Local Impact Report.

Prepared by	Lucy Baxter (Senior Planning Officer) Elizabeth Verdegem (Team Leader (Strategic) – Development Management)
Date	November 2025
Purpose	Local Impact Report on Green Hill Solar Farm (PINS reference EN010170)

Title:
Figure 13.4 (Rev A): HGV Routes to Scheme
(Central Area)

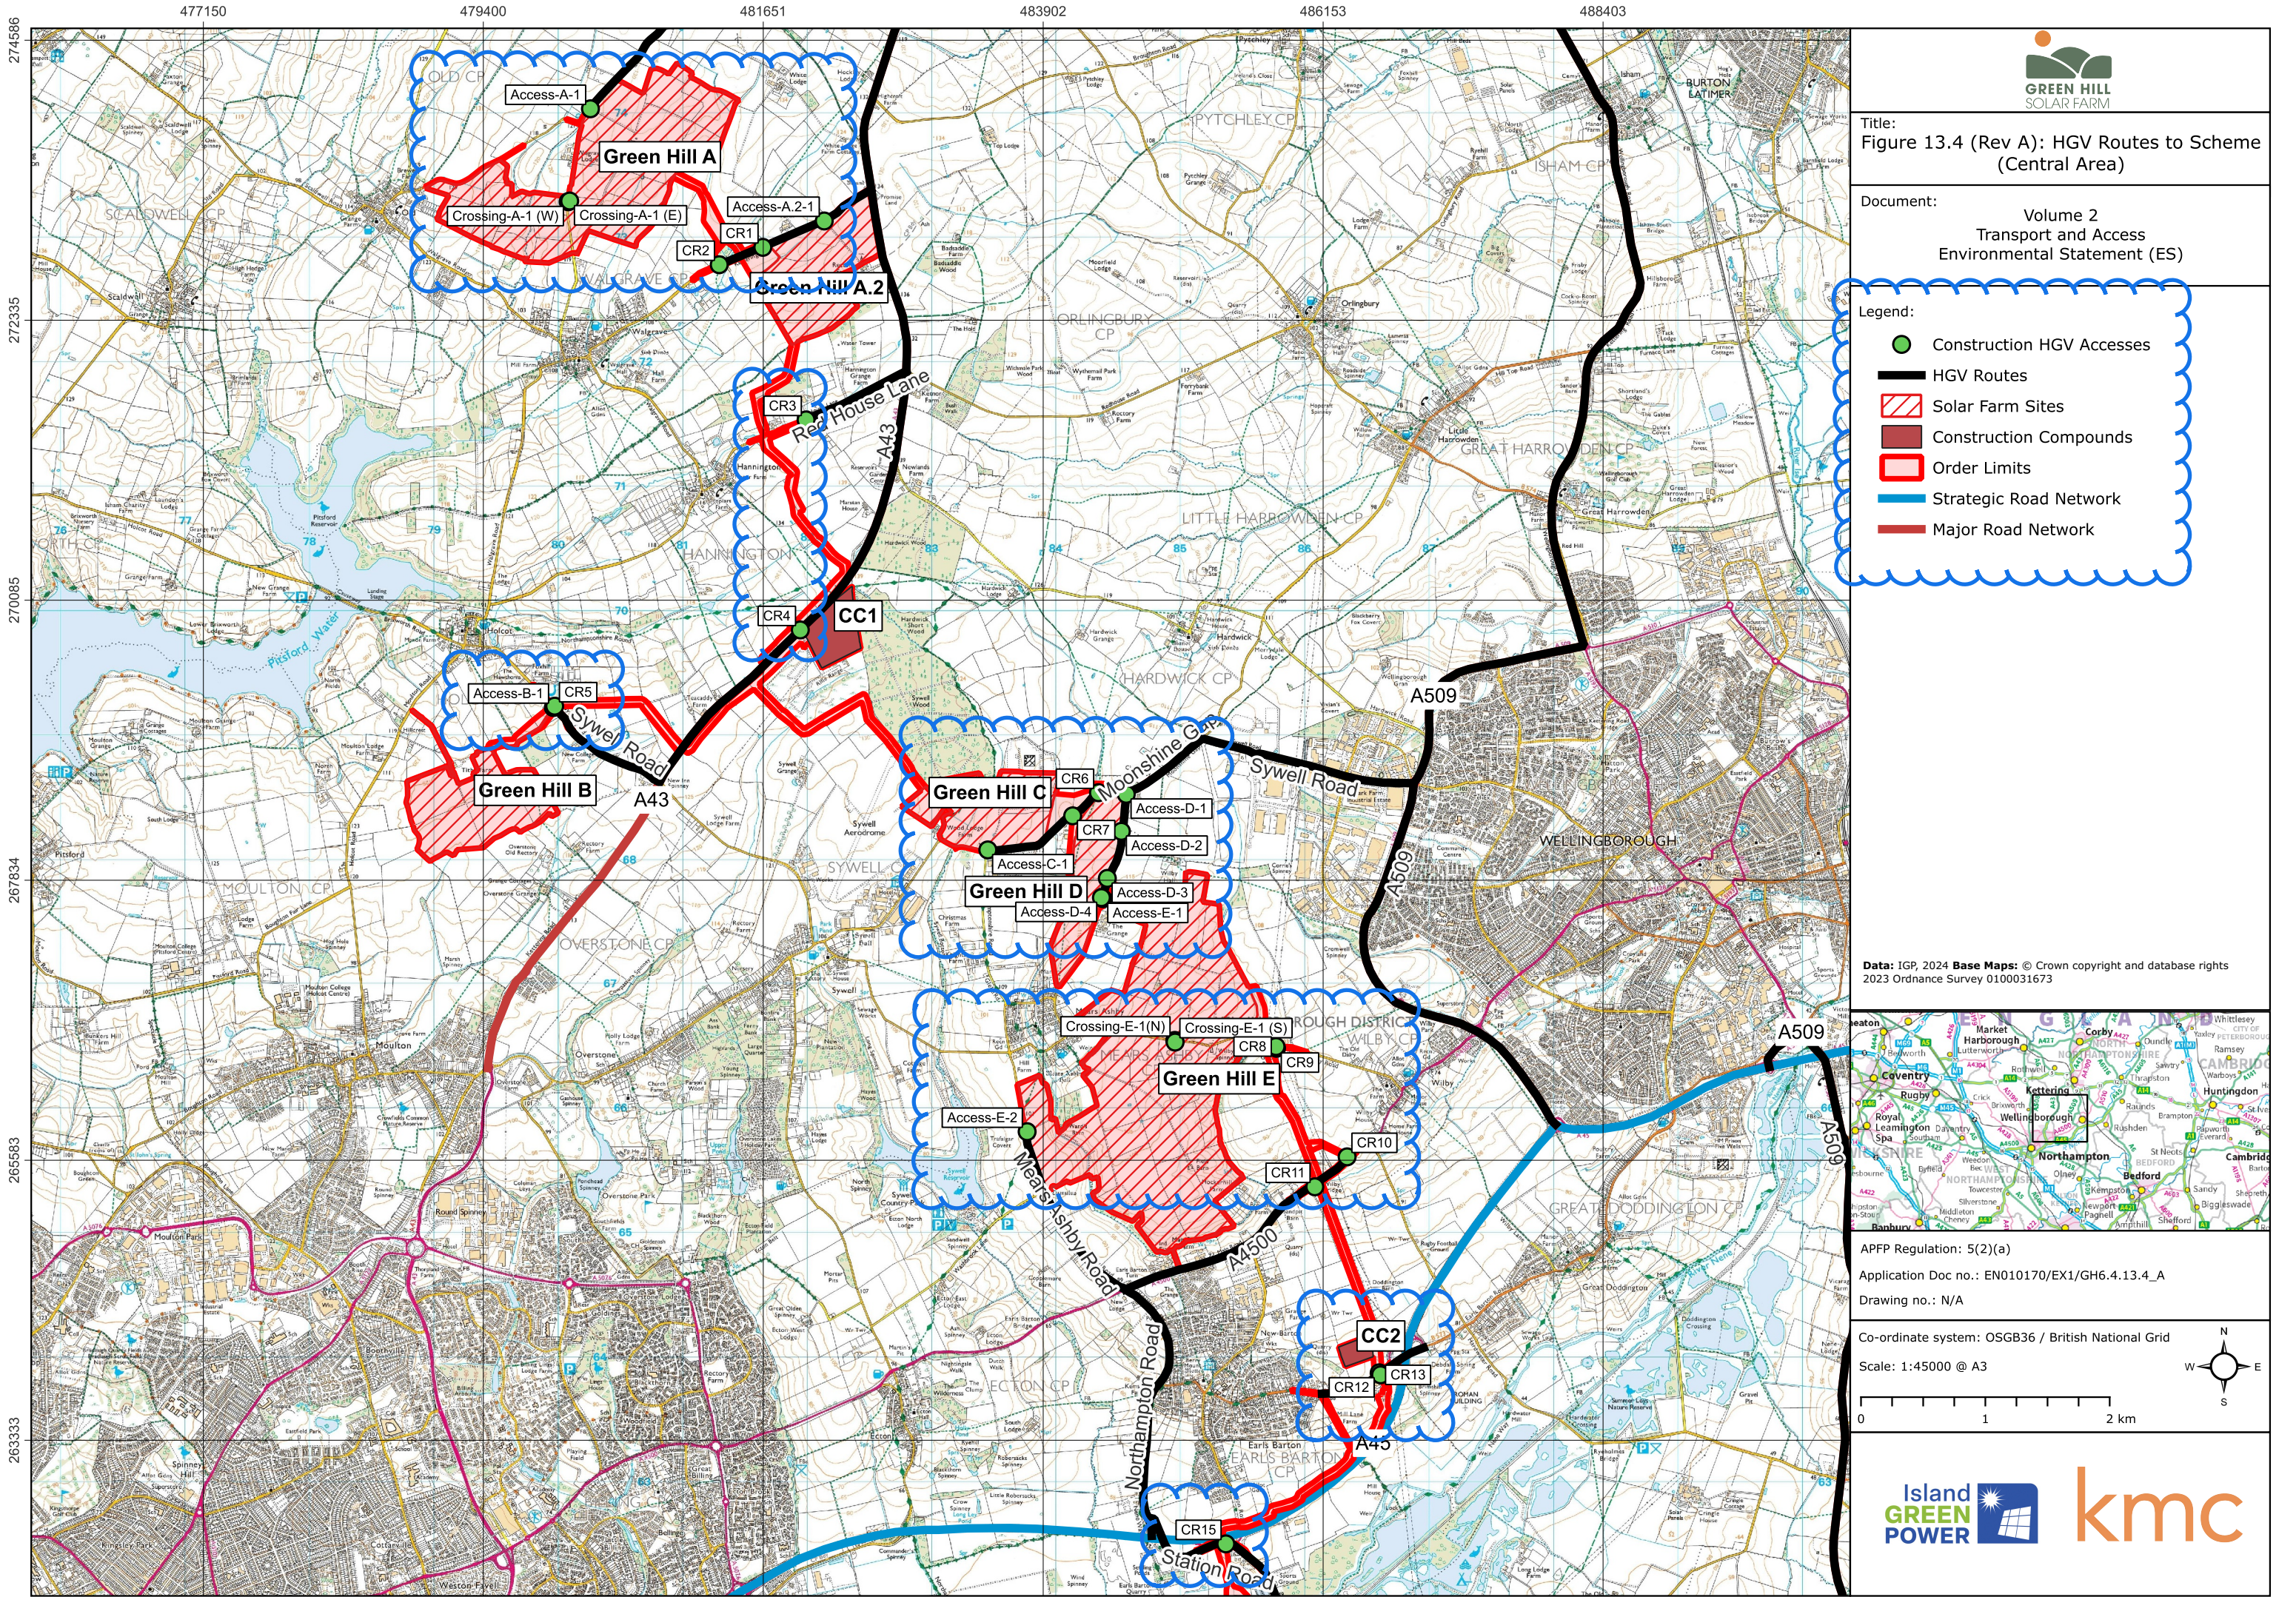
- 4.38 The traffic movement forecast demonstrates an anticipated 8 HGV trips on average, with a peak of 18 two-way movements during construction. The applicant's routing plan clarifies that normal construction HGV traffic will enter the site from the north via the A509 and A428 (i.e. not through Lavendon, or Olney) from the A45. MKCC consider this acceptable as the preferred route for HGV to limit impacts on surrounding villages.

- 4.46 Before the level of impact on the broader highway network can be agreed a more robust approach to traffic generation is required. In particular, with reference to a very high percentage of workers coming by shuttle bus. Further the A428 access into Site G requires further improvement to allow two vehicles to pass.
